# LITTLE WALTHAM PARISH COUNCIL

Re: Longfield Solar Farm

I am contacting you on behalf of Little Waltham Parish Council. The Parish Council wishes the following submission to be taken into account in the examination of the application for the Longfield Solar Farm –

Figure 1. Location and proposed land take

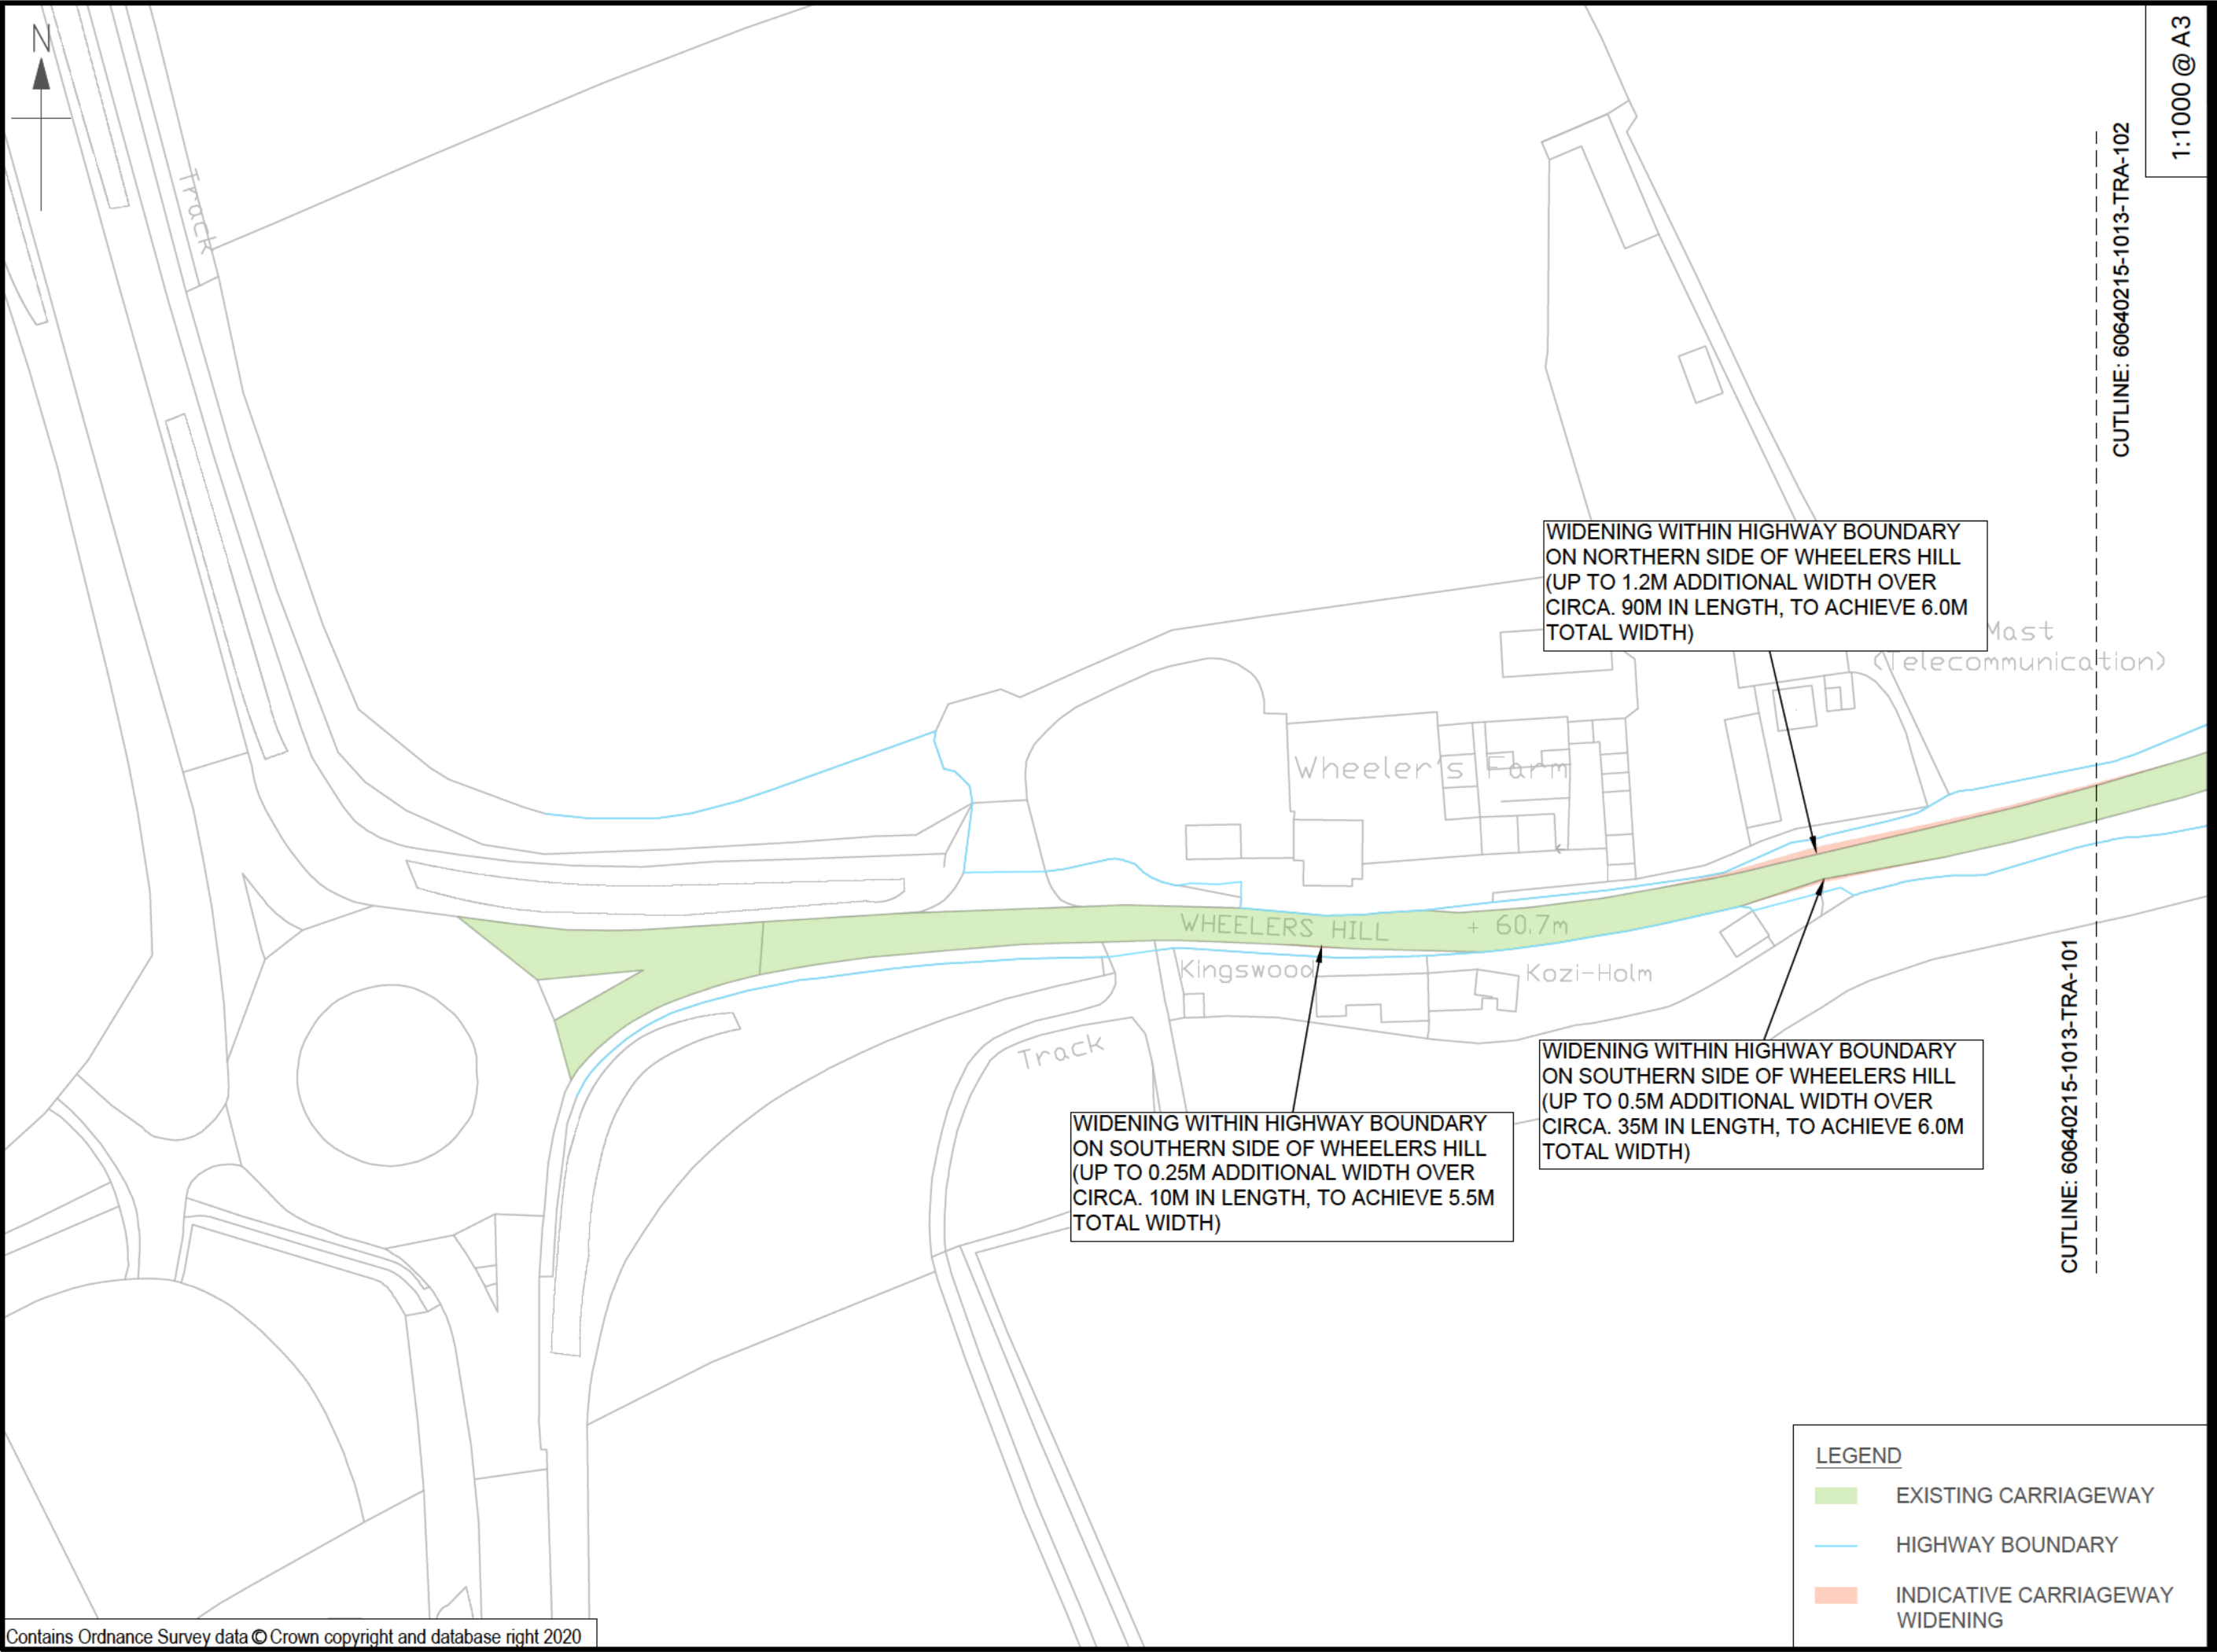
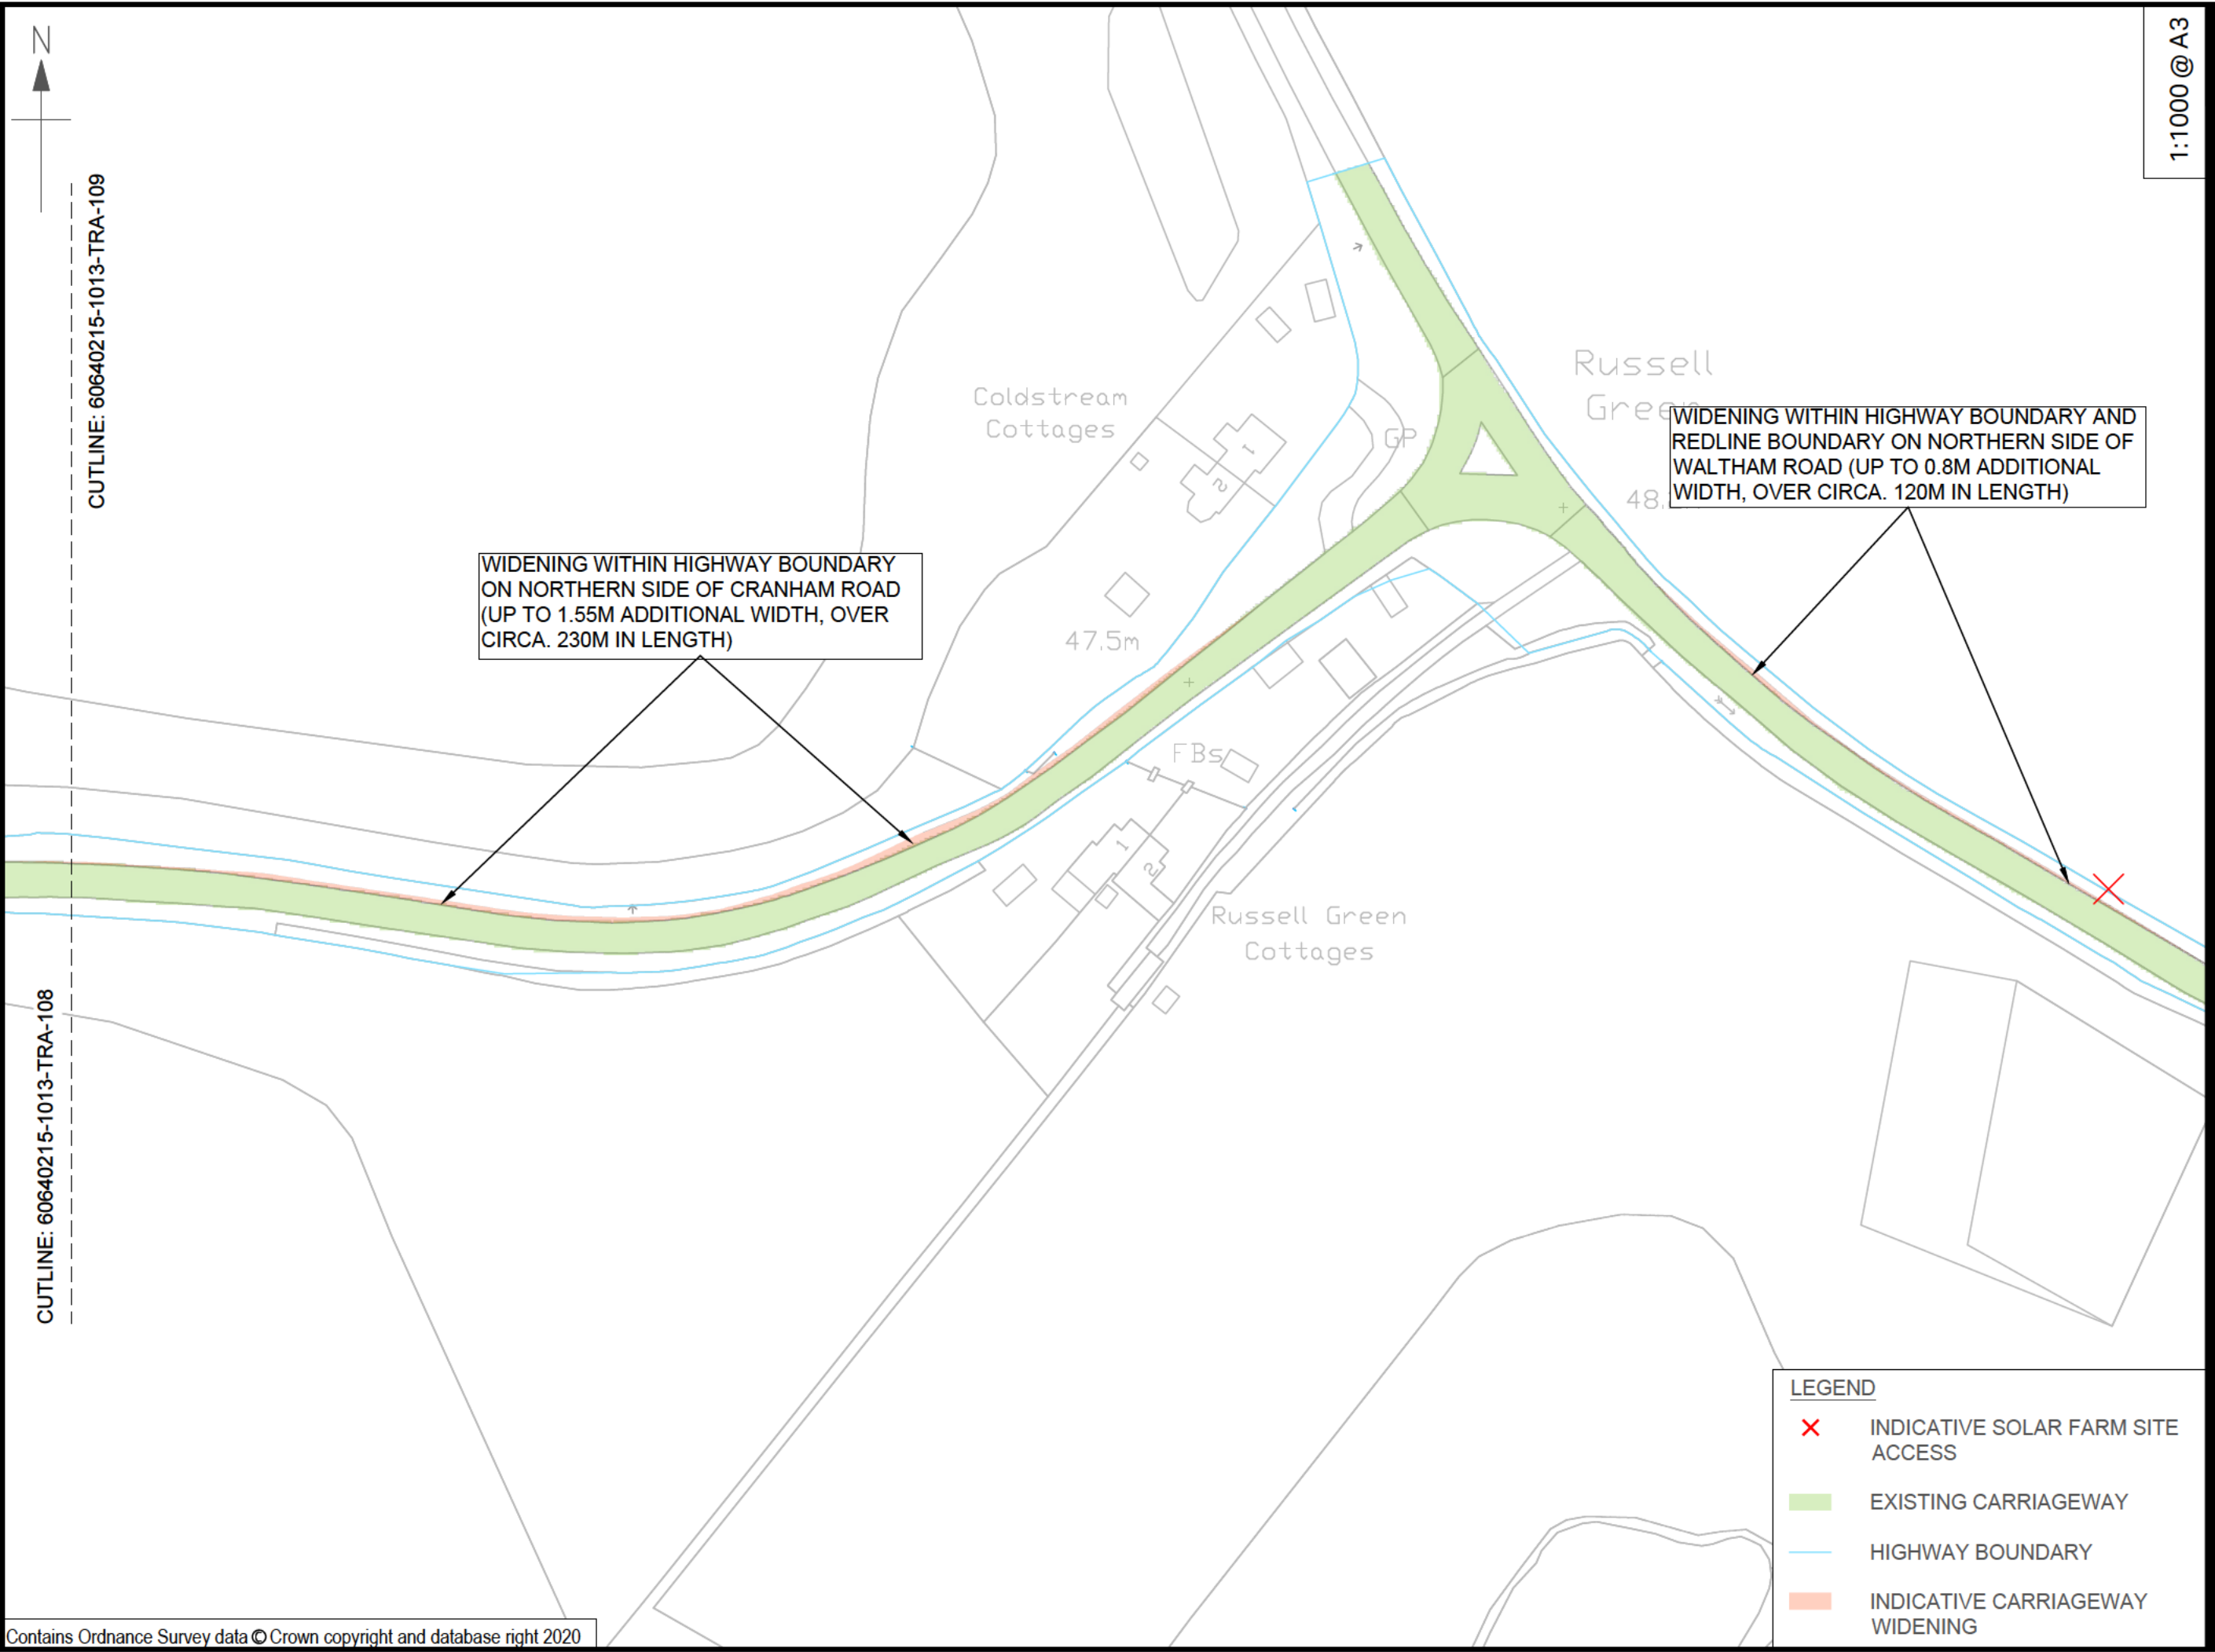
It is noted that the main access to the proposed solar farm would use Cranham Road.

The Parish Council wishes it to be noted that this road is a wholly inappropriate road to use to access the solar farm in its current condition.

The road is a narrow rural road that can barely accommodate existing traffic as evidenced by damage to the grass verges over recent years.

Therefore, unless work is carried out to the road to widen and improve it, then the Parish Council objects to Cranham Road being used as the main access to the site.
